APPLEGREEN PLC

**M42 Junction 6
Development Consent Order Application**

RESPONSES TO EXAMINING AUTHORITY'S SECOND WRITTEN QUESTIONS

16th August 2019

Figure 1: Junction 5a Free Flow Alternative Layout

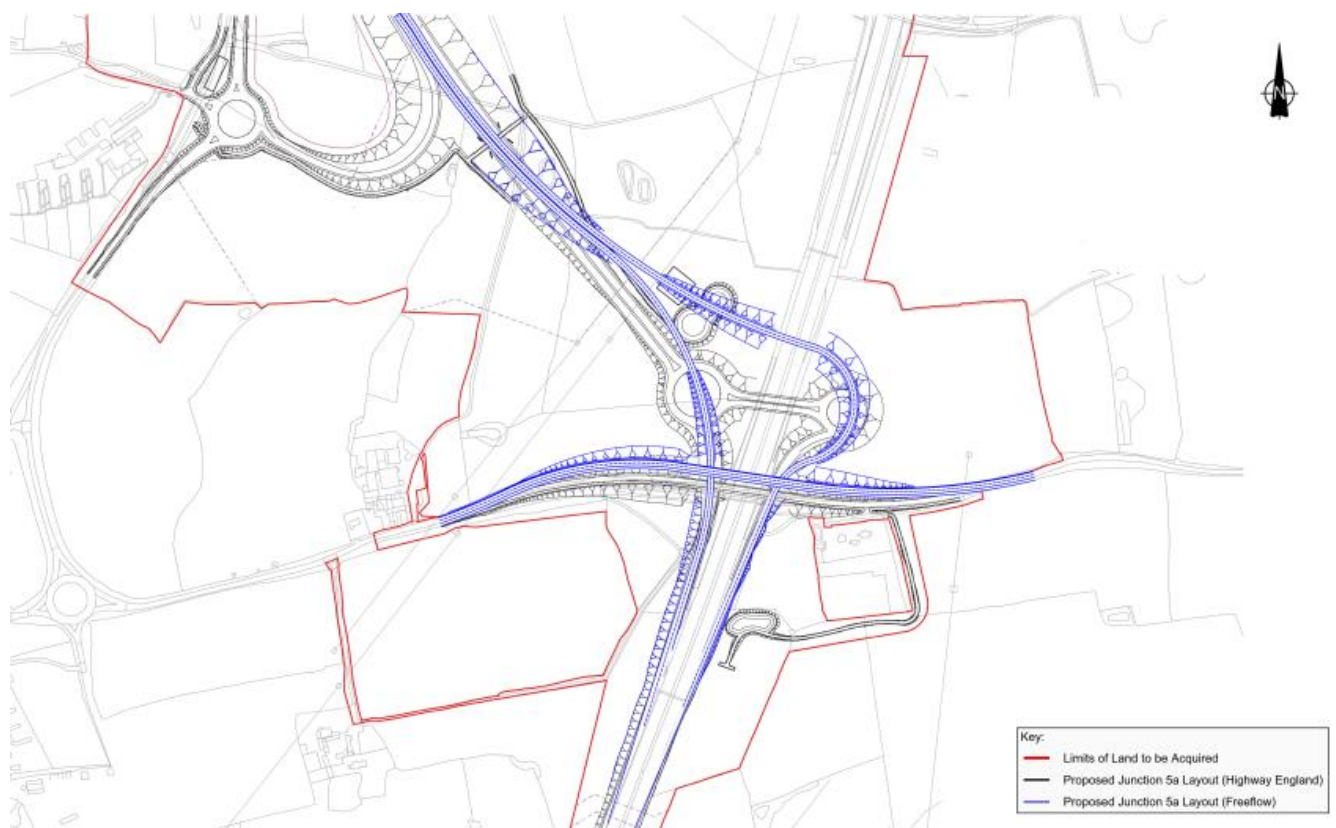
2.1.5.	<p>The Applicant, SMBC, WCC, Extra MSA Solihull Ltd and Applegreen plc</p>	<p>MSA and junction 5a Please revisit and reassess the advantages claimed for the proposed dumb-bell design for junction 5a in the answer to ExQ1.0.10 in relation to the free-flow design suggested by Applegreen in their Technical Note appended to REP3-024. Since a consequence of the proposed design necessitates the widening of the western roundabout and a section of the link road in order to accommodate MSA traffic, please include all those alterations in the reassessment (particularly, the additional lanes and the additional span of Solihull Road Bridge required). In the light of that reassessment, does the published layout in the dDCO provide the optimum junction arrangement and meet the scheme objectives as defined in the Planning Statement?</p>	<p>The DCO Scheme objectives are set out in Section 3.5 of the Planning Statement. Paragraph 3.5.1 identifies the two strategic requirements in line with the Roads Investment Strategy (RIS). These are:</p> <ul style="list-style-type: none"> • <i>increasing capacity, providing improved journey time reliability and reducing congestion at the M42 Junction 6 and for better movement of traffic on and off the A45; and</i> • <i>unlocking the potential for economic growth in the surrounding area, delivering ahead of the need for growth from HS2 and the surrounding developments.</i> <p>Paragraph 3.5.2 sets out that the scheme has four specific objectives, namely:</p> <ol style="list-style-type: none"> a) Making the network safer: Promote reliable and safe operation of the road Network. The specific measures to improve safety are identified as: ... <i>providing additional capacity, reducing driver stress and enabling safer access to and from the motorway.</i> b) Support the smooth flow of traffic: Increase the capacity of the junction supporting smoother flow of traffic around the M42 Junction 6. c) Encourage economic growth: To improve access to key businesses and support economic growth in the area from the new HS2 Birmingham interchange station and connectivity to Birmingham Airport. d) Helping cyclists, walkers and other vulnerable users of the Network: To replace or re-route existing severed links and provide new routes. <p>Finally paragraph 3.5.3 identifies four secondary objectives:</p> <ol style="list-style-type: none"> a) Deliver better environmental outcomes: The Scheme will mitigate and compensate its biodiversity impacts. b) Improve user satisfaction: Seek to minimise disruption and road closures during construction. c) Achieving real efficiency: The scheme should aim to match or improve the allocated budget within the category of £250m to £500m as defined in the RIS investment plan commitments. d) Keeping the network in good condition: Replace pavement associated with SRN connection points at Junction 6. <p>It is noted that avoiding precluding the provision of a MSA at Junction 5A is not listed as either a primary or secondary scheme objective.</p> <p>Whilst the scheme objectives are crystal clear, it is noted that Appendix 4 of the Planning Statement (the Junction 5A Technical Note / Design Rationale) seemingly references a further, vague objective. Paragraph 3.17 of</p>

The extent to which the proposed dumb-bell junction and the alternative free-flow layout are each compatible with, and best meet, the DCO Scheme objectives (as defined in Section 3.5 of the Planning Statement) are set out in the table below.

PRIMARY SCHEME OBJECTIVES	
DUMB BELL ARRANGEMENT	FREE FLOW ARRANGEMENT
Objective: Making the network safer: Promote reliable and safe operation of the road Network – specifically by way of: providing additional capacity, reducing driver stress and enabling safer access to and from the motorway	
<ul style="list-style-type: none"> • Provides additional capacity by removing traffic from Junction 6 	<ul style="list-style-type: none"> • Provides additional capacity by removing traffic from Junction 6
<ul style="list-style-type: none"> • Includes roundabouts which will (with or without any MSA) ultimately become the primary constraining factor on capacity through the junction 	<ul style="list-style-type: none"> • Has no roundabouts that could constrain capacity
<ul style="list-style-type: none"> • The dumb bell arrangement allows the junction to be used to facilitate ‘U’ turns on the motorway, with 	<ul style="list-style-type: none"> • The free flow arrangement prevents the junction being used to facilitate ‘U’ turns on the motorway, with such

Objective: Support the smooth flow of traffic	
			<ul style="list-style-type: none"> The proposed dumb-bell arrangement would not lead to the smooth flow of traffic through Junction 5A owing to the stop lines and conflicting traffic movements that would occur at the roundabouts and which would introduce a disruption to vehicular flow 	<ul style="list-style-type: none"> The free-flow alternative has no stop lines or conflicting traffic movements. It would also have materially less potential for congestion. Accordingly, it would result in the far smoother flow of traffic through Junction 5A

<p>Based on the forgoing analysis, it can be seen that a free flow arrangement at Junction 5A better meets each and every one of the DCO Scheme objectives (both primary and secondary) than the currently proposed dumb bell arrangement.</p> <p>There can be no material doubt that the current dumb bell proposal is being promoted by the applicant for the sole reason of not precluding the development of a MSA at Junction 5A and the associated provision of north facing slip roads. This decision to not preclude the MSA is not a DCO Scheme objective and has been shown to hinder, or conflict with, the Scheme best achieving its real and important objectives.</p>

Figure 4: Relative Impact on Ancient Woodland

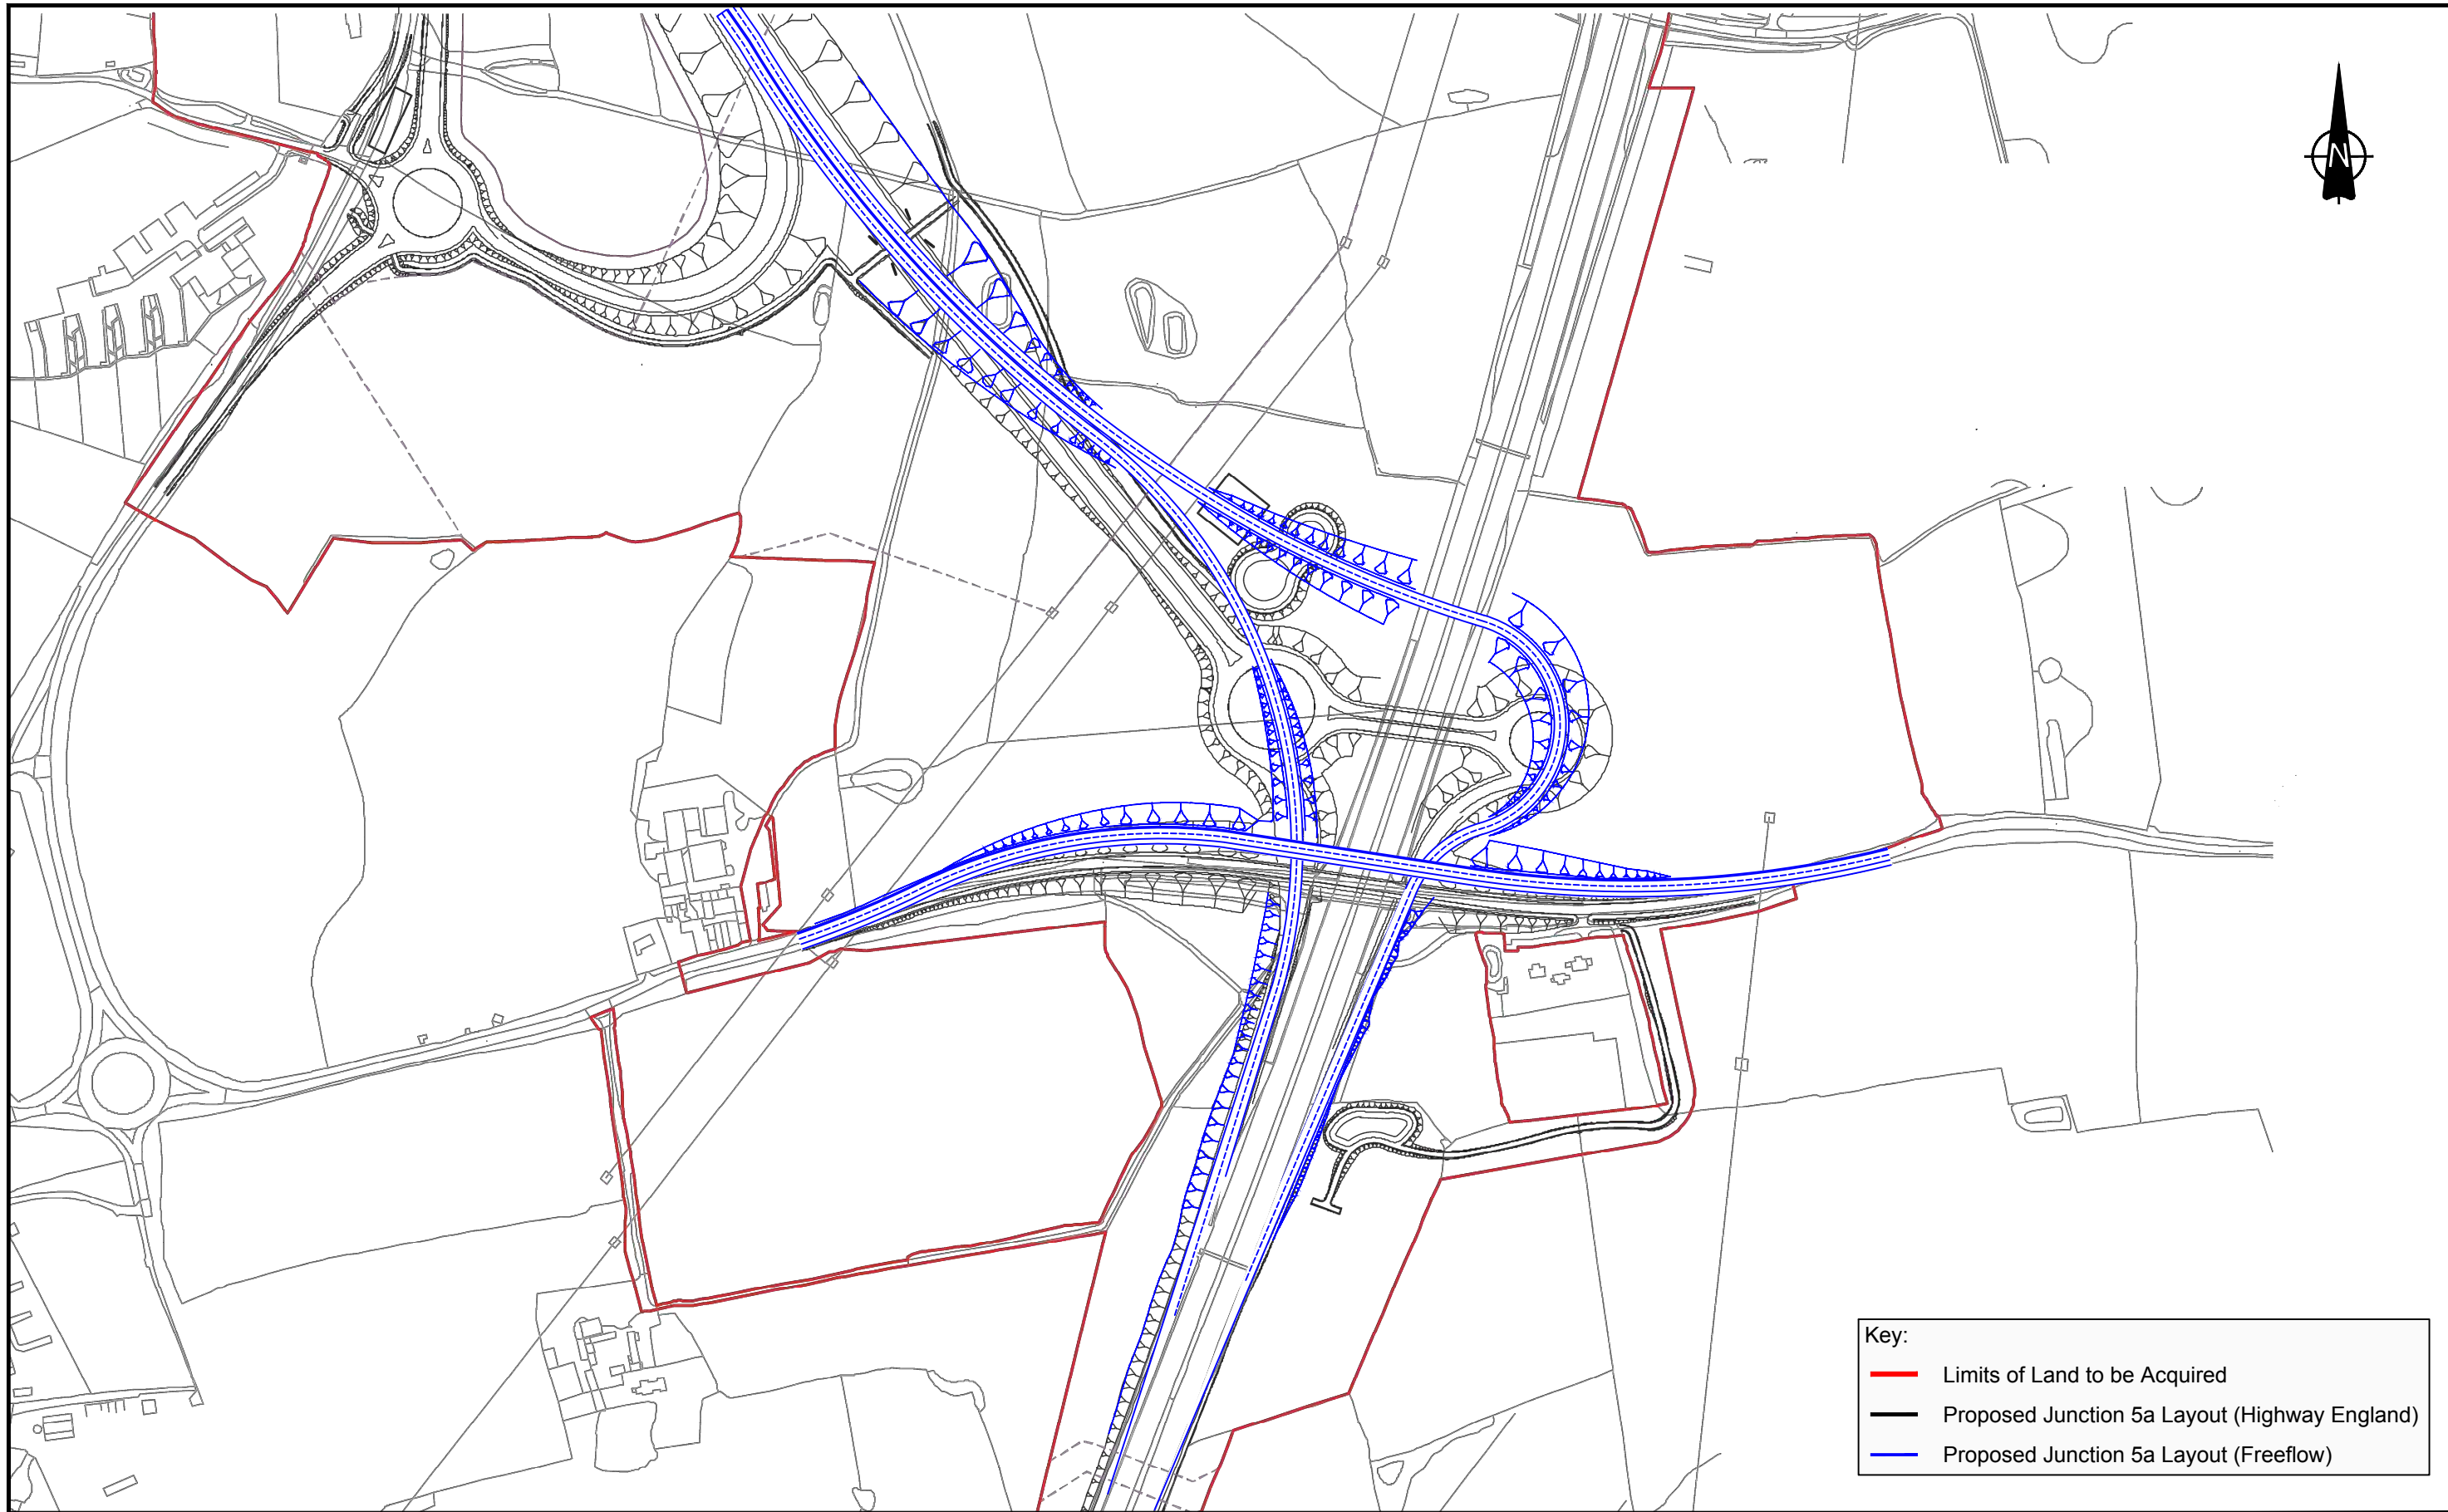
<ul style="list-style-type: none"> Impacts on Asbury's Copse Ancient Woodland to the west of the M42 and the south of Solihull Road 			<ul style="list-style-type: none"> As per the Applegreen Technical Note (appended to REP3-024), the alignment and level of Solihull Road that could be achieved with the free flow alternative would mean that no earthworks would be required to the south of the existing Solihull Road corridor to support Solihull Road and there would, therefore, be no impact on the northern edge of the Ancient Woodland The overall loss on Ancient Woodland would be materially reduced

<ul style="list-style-type: none"> • The provision of extra lanes to serve the MSA and the associated additional span of Solihull Road overbridge, appears to have significant potential to further increase the impact on the Ancient Woodland, although this cannot be fully determined / quantified in the absence of a design incorporating these features. 	<ul style="list-style-type: none"> • There are no additional lanes and no further widening of the span of Solihull Road overbridge; and thus no potential for further impact on the Ancient Woodland.
		<ul style="list-style-type: none"> • The requirement for the slip roads to be higher than the motorway mainline where they pass under Solihull Road means that the new Solihull Road bridge will have to be significantly higher than at present. It is judged that the road bridge would be a minimum of circa 4m higher than at present with a degree of associated visual impact. 	<ul style="list-style-type: none"> • With the free flow alternative the proposed slip roads would be kept at the same level as the motorway mainline meaning that the clearance from the mainline would determine the height of the bridge. This also allows Solihull Road to be aligned further north without needing to be higher.
